ExQ1	Question to:	Question:
<b>1. General and cross-topic questions</b>		
<b>1.0 Planning and Infrastructure Act 2025</b>		
Q1.0.1	All IPs	<p><b>Planning and Infrastructure Act 2025</b></p> <p>The Planning and Infrastructure Act received Royal Assent on Thursday 18 December 2025. All IPs, including the applicants, are invited to submit comments on the new Act in relation to any implications for the examination of this application.</p>
<b>1.1 Development plan</b>		
Q1.1.1	North West Leicestershire District Council (NWLDC) Leicestershire County Council (LCC) Neighbourhood plan bodies	<p><b>Development plan</b></p> <p>Could the identified interested parties please provide copies of the development plan for which they are responsible along with any associated policy maps. Where a development plan is under review, could the identified interested party, also provide information as to the stage of review that the plan has reached, along with a timetable through to adoption/ making. This should be updated throughout the examination should it change. Where a draft development plan document exists, please could a copy also be provided (along with any associated maps). Again, this should be u

number FIGURE 1 rev -

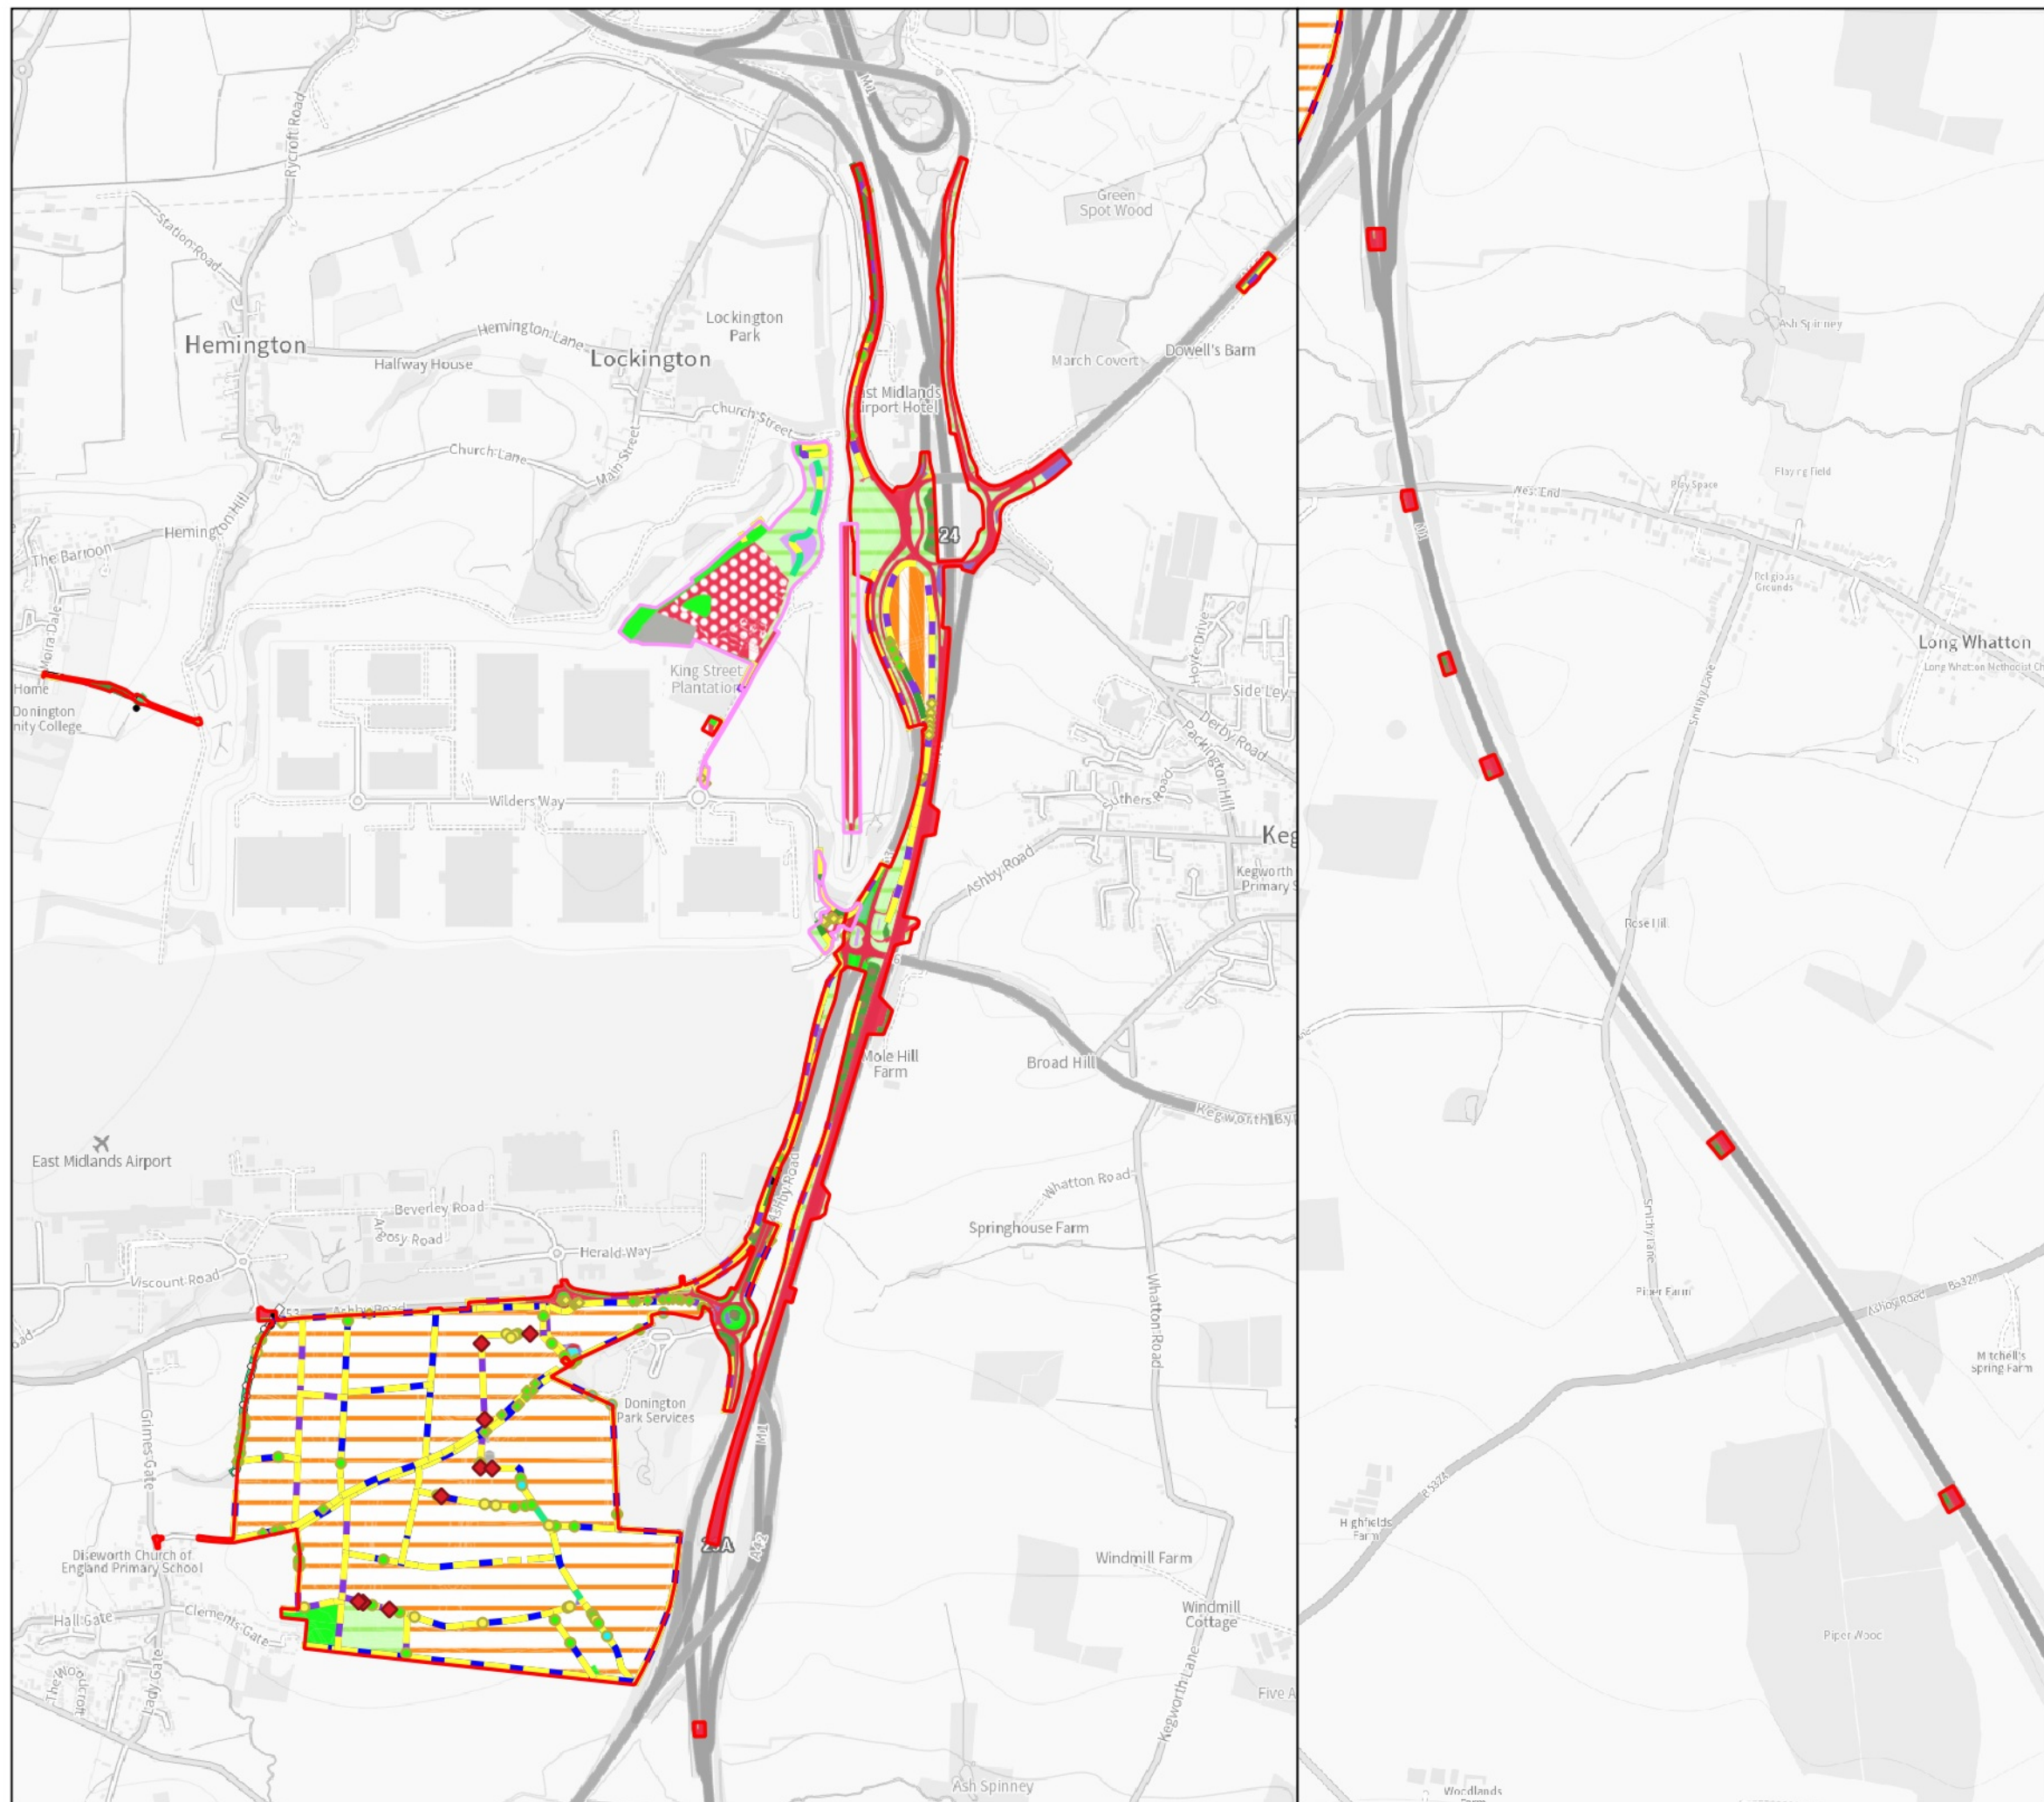
Q5.0.16	The applicants	<p><b>Works no. 10 hedgerow loss</b></p> <p>Figure 3 of the BNG Report [APP-116] shows what looks to be a significant length of hedgerow loss associated with Works No. 10 (A50 westbound merge). Can the applicants please explain the importance of this length of hedgerow for protected species, including as a foraging or commuting route for bats present in the area? If it is important, please can the applicants provide more detail on how its loss would be mitigated?</p>

Figure 8c.1: Modelled Receptor Locations – Disworth

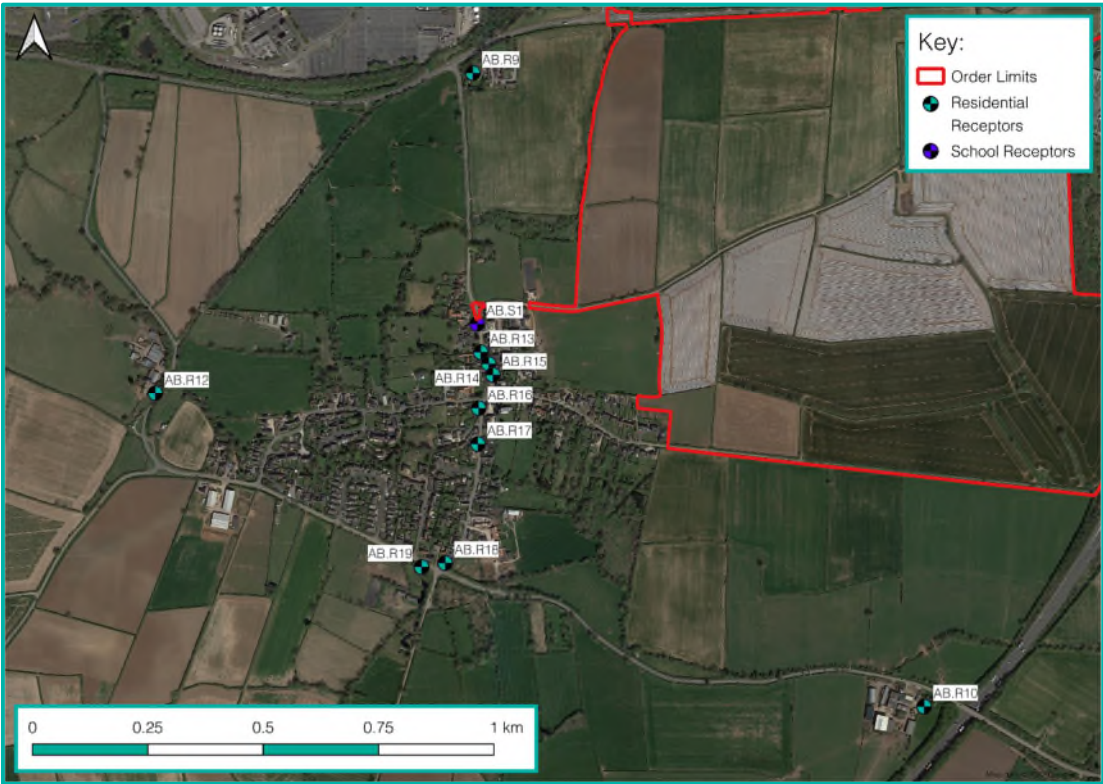
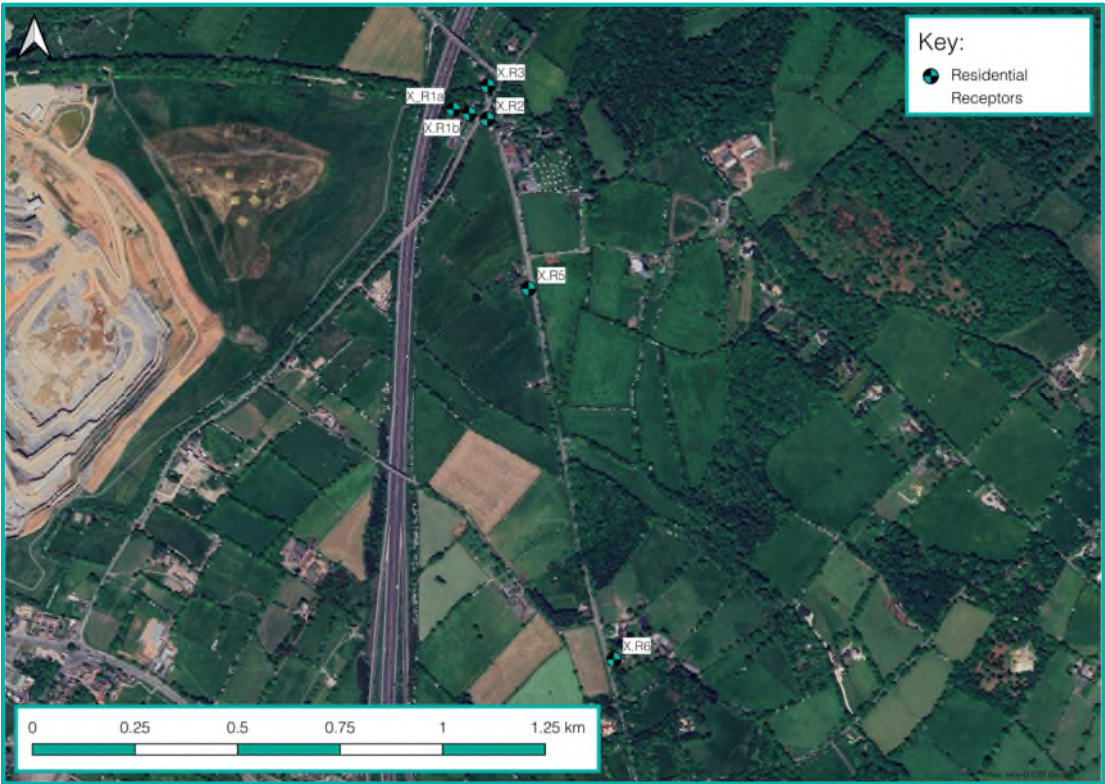
ExQ1	Question to:	Question:
Q4.0.17	The applicants	<p><b>Air quality management areas</b></p> <p>Can the applicants check that appendix 8G <a href="#">[APP-104]</a> references and illustrates all of the AQMA's cited in chapter 8 of the ES <a href="#">[AS-037]</a>. For example, Castle Donnington AQMA is illustrated on some but not all of the figures. Furthermore, it is not clear whether Copt Oak or Derby AQMAs have been appropriately referenced and illustrated at all.</p>
